M5 Junction 10 Improvement Scheme (Ref: TR010063)

ISH4 Submission
[REDACTED]

19th September 2024

Drawing Title	GENERAL ARRANGEMENT PLANS REGULATION 5(2)(o) SHEET 13 OF 16
---------------	---

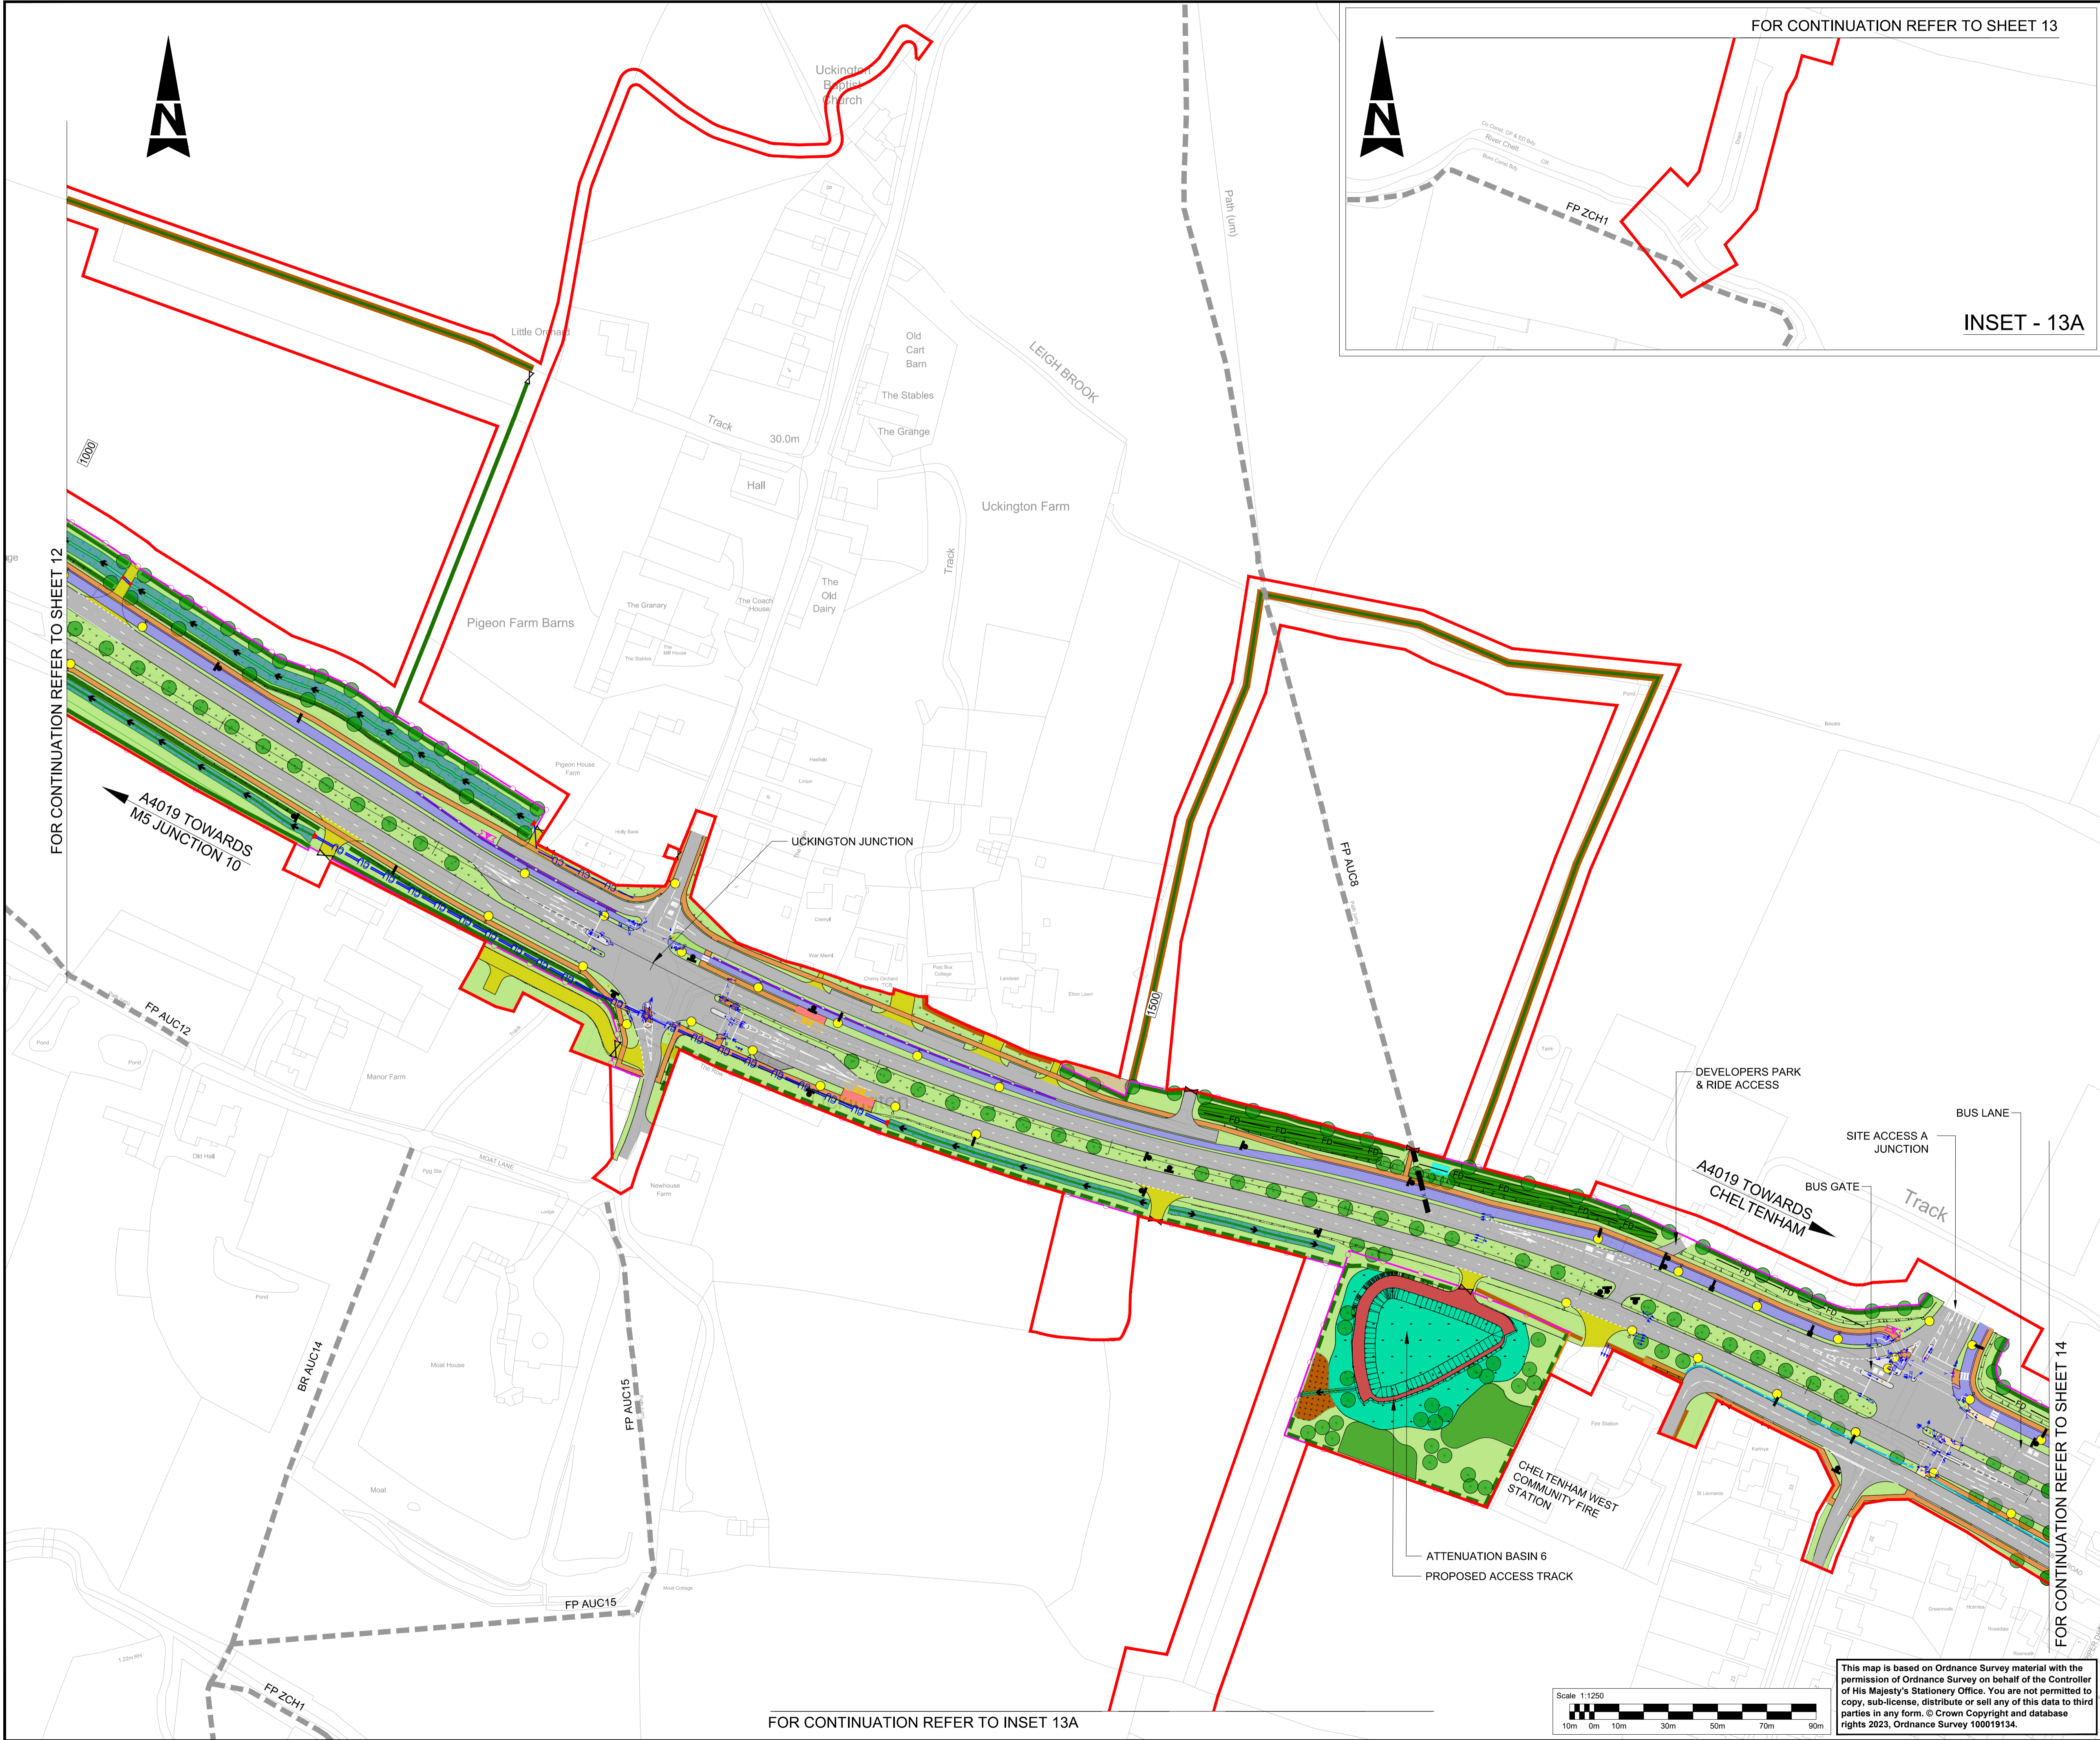
I am the landowner of [REDACTED] as shown on Sheet 13 of 16 of the Land Plans. The frontage abuts the North side of the A4019 and the property includes an adjoining meadow to the North up to the Leigh Brook of approx 2 acres giving valuable recreational amenity.

With respect, I consider, as the landowner affected, I am entitled to certainty at this stage, by way of an upgraded version of acoustic barrier, because I do not consider the basic version would provide the mitigation expected and to which I am entitled. My view appears to be confirmed by the assessment of 'Slight Adverse' in Year 1 and again 'Slight Adverse' in Year 15, but that the key aspect of this is the proposed lighting columns. My reaction to this is that it is simply not good enough and further I would strongly object to lighting columns being located directly outside the property as I find it difficult to see any reason why they could not be located otherwise.

As I mentioned at the preliminary meeting I have major concerns that the acoustic barrier, as currently indicated, terminates some distance prior to the Eastern boundary of the [REDACTED] property. I find this unacceptable and inconsiderate. As well as failing to provide any protection for a large part of the garden, noise generated East of the current termination point would inevitably impact on the property. As I also mentioned at the preliminary meeting, road noise generated from a single modest sized vehicle travelling at a modest speed is of itself significant and the extent to which this is compounded by large volumes of vehicles and HGVs of various description is the reality one is faced with. I, therefore, again request that serious consideration is given to the extension of the currently proposed Eastern termination point so that the appropriate and necessary protection and mitigation can be provided. I would appreciate some dialogue and a site meeting with the Applicant's noise specialists involved to address and take this issue forward.

I, therefore, respectfully request that the actual design, specification and quality of the acoustic barriers, both as to the Landscape and Visual and Noise aspects take my comments into full account.
